DRB Application No.: 09 DRB - 70196 Project # 1006768  
 Project Name: Heights Reservoir  
 Agent: SUN-DEK Phone No.: \_\_\_\_\_

7. ~~Project# 1006768~~  
09DRB-70196 MINOR - PRELIMINARY/  
FINAL PLAT APPROVAL
- SURV-TEK INC agent(s) for SAN MATEO & LOMAS, LLC request(s) the above action(s) for all or a portion of Tract(s) 29A-1-A AND 291-1-B, **HEIGHTS RESERVOIR ADDITION** zoned CCR-3, located on LOMAS BLVD NE BETWEEN SAN MATEO BLVD NE AND MANZANO ST NE containing approximately 3.0486 acre(s). (K-17) **THE PRELIMINARY/FINAL PLAT WAS APPROVED.**

**DRB CASE NO/PROJECT NO: 1006768**

Development Review Board 8/29/07 Agenda Item #10  
Sketch Plat: Tract 29A-1, Heights Reservoir Addition

SKETCH PLAT
OF
TRACT 29A-1-A, 29A-1-B AND 29A-1-C
HEIGHTS RESEVOIR ADDITON
(BEING A REPLAT OF TRACT 29A-1
HEIGHTS RESEVOIR ADDITION)
CITY OF ALBUQUERQUE, BERNALILLO COUNTY, NEW MEXICO
AUGUST 2007

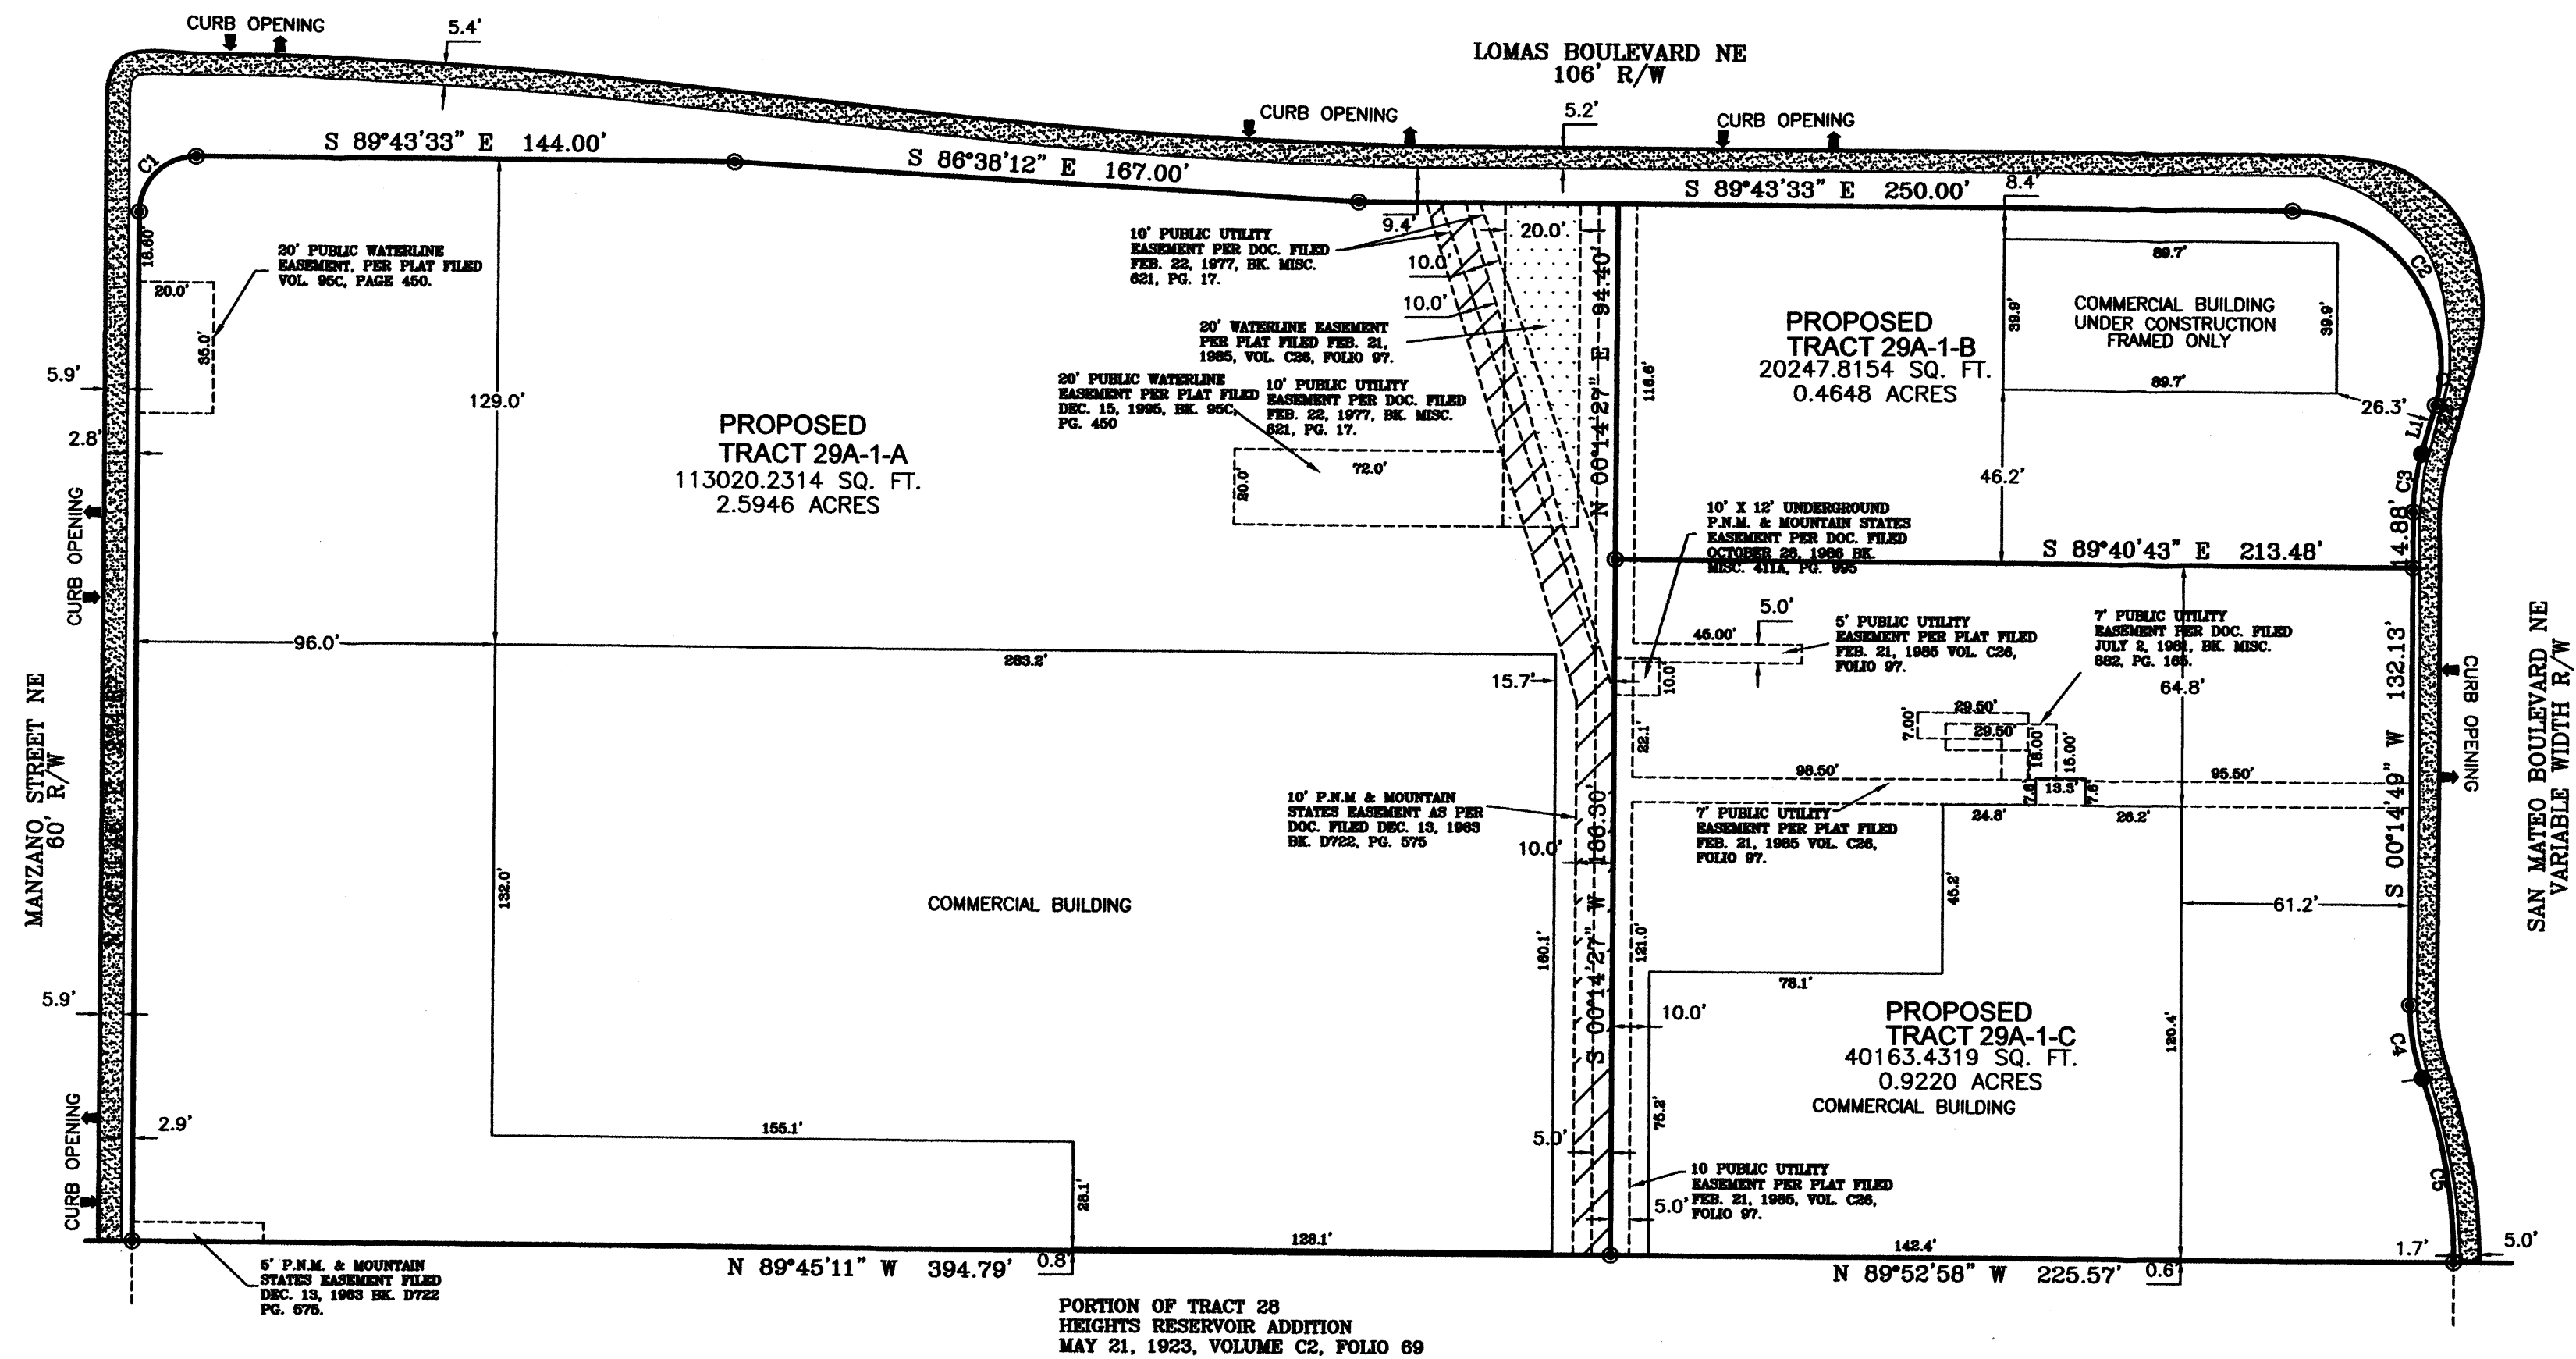
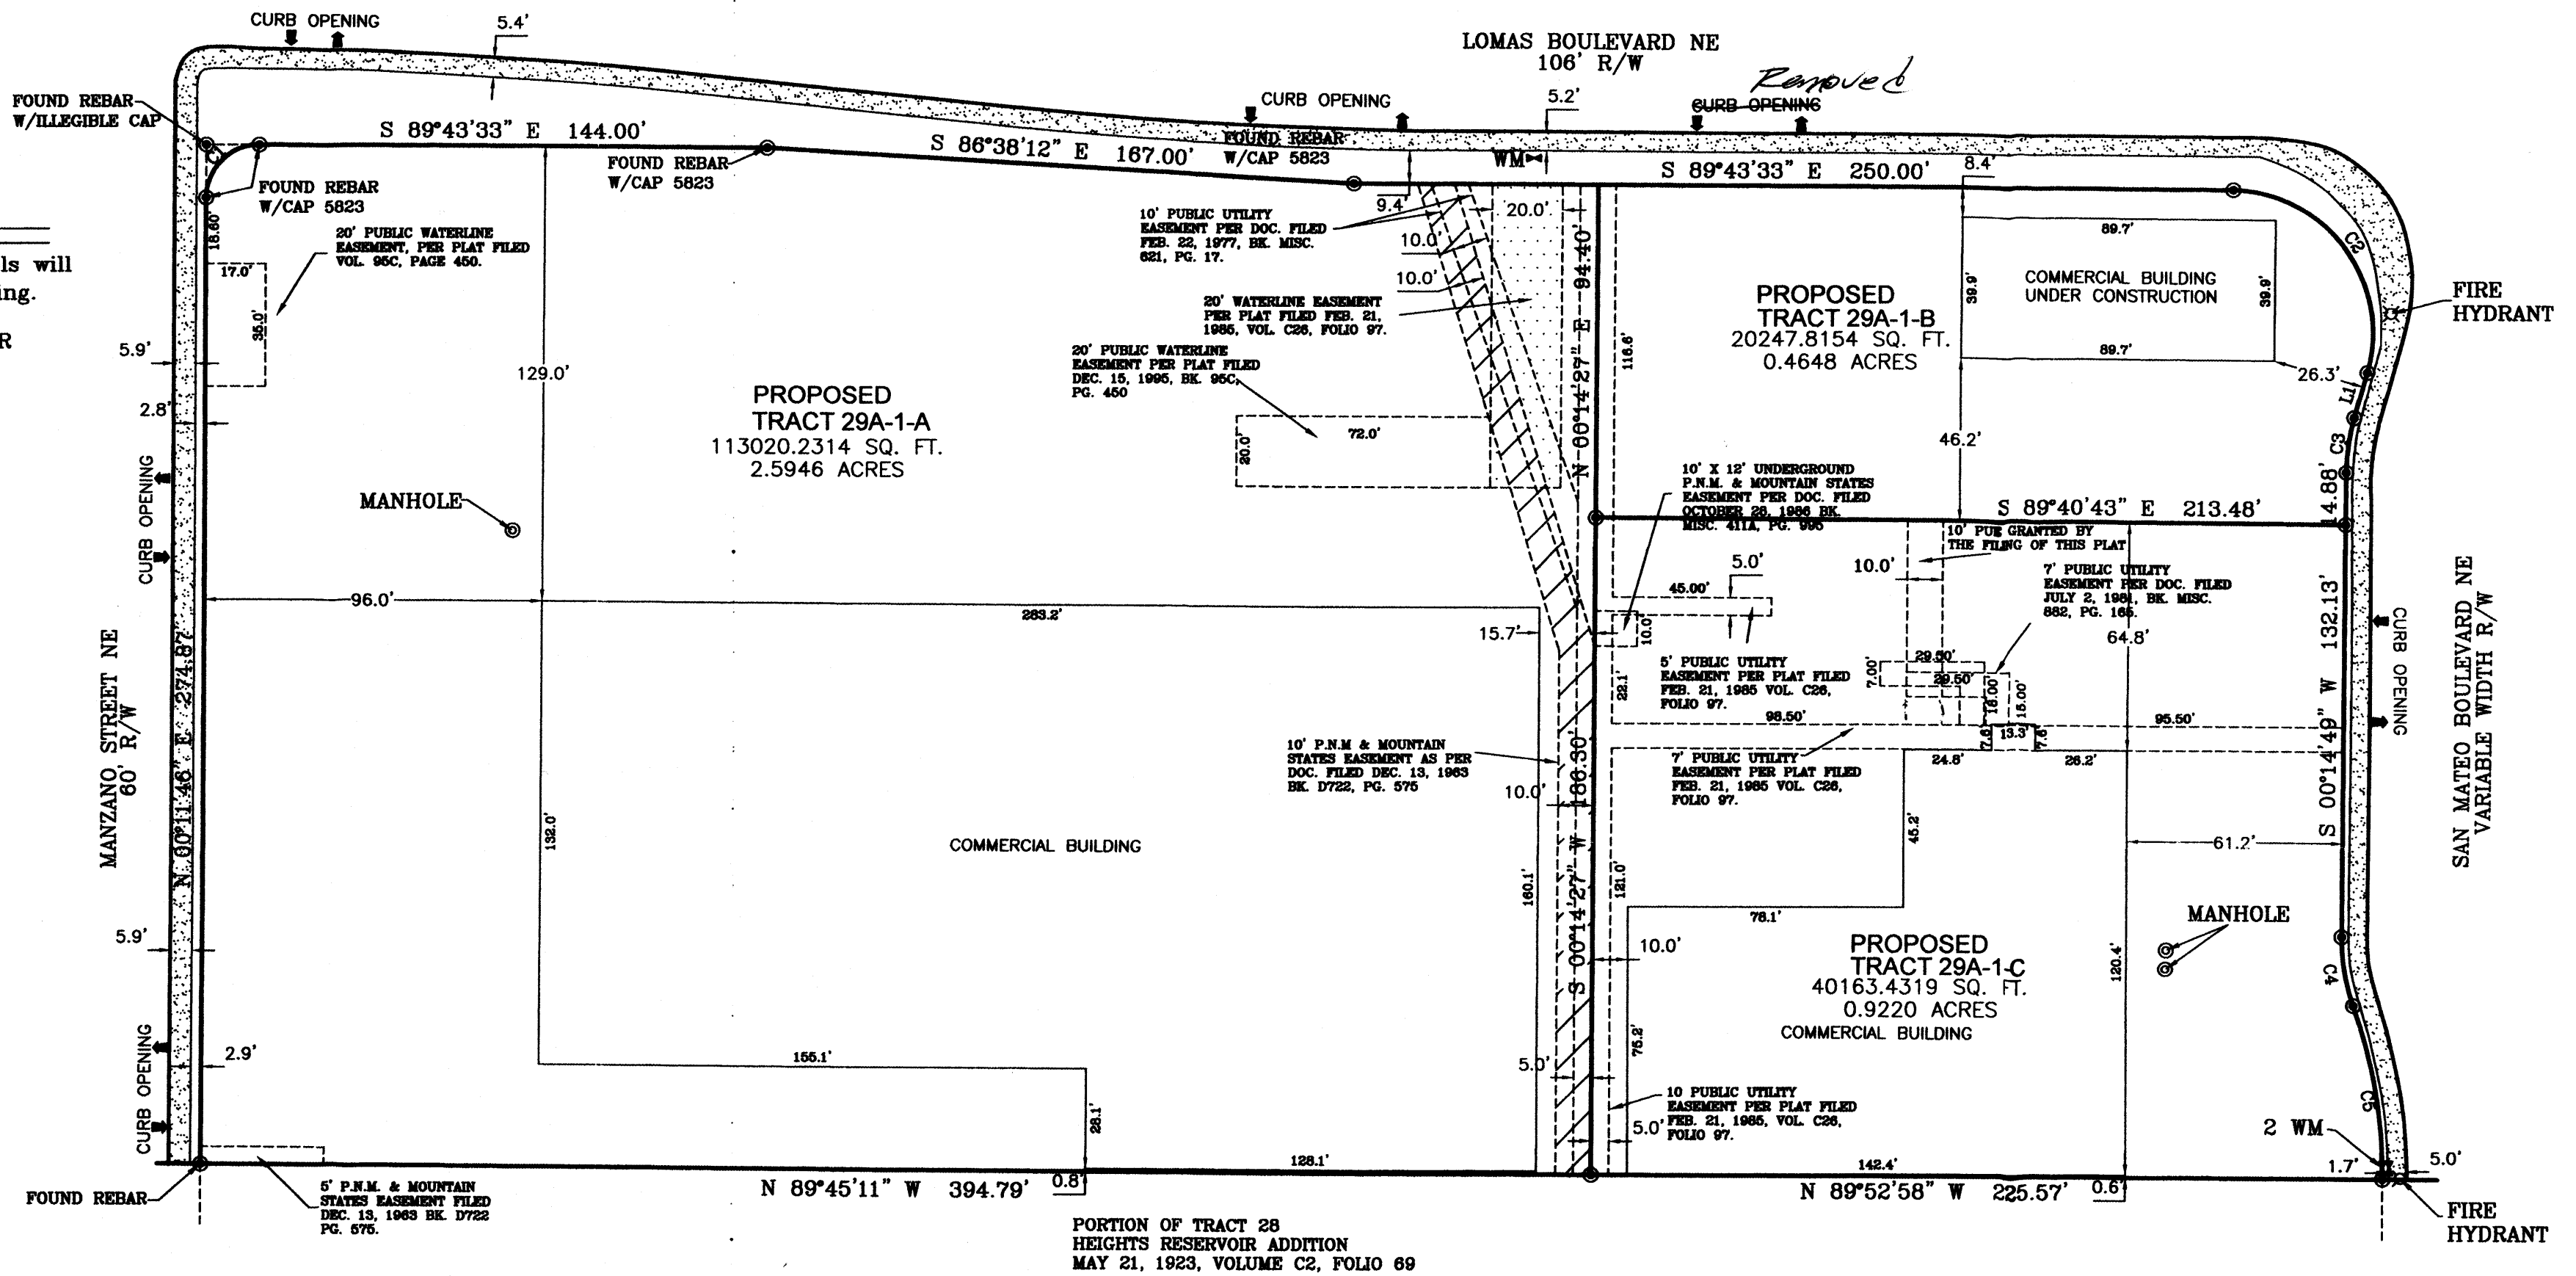
<u>No.</u>	<u>Comment</u>
1)	What are the distances from face of curb to the property lines?
2)	Are the sidewalks in place? (These should be 6' sidewalks)
3)	The lots will need cross access.
4)	A number of the existing curb openings will need to be closed. (Has the building permit been issued?)
5)	The required parking for each lot will need to be contained within the new lots created.

A cross lot drainage easement will be required.
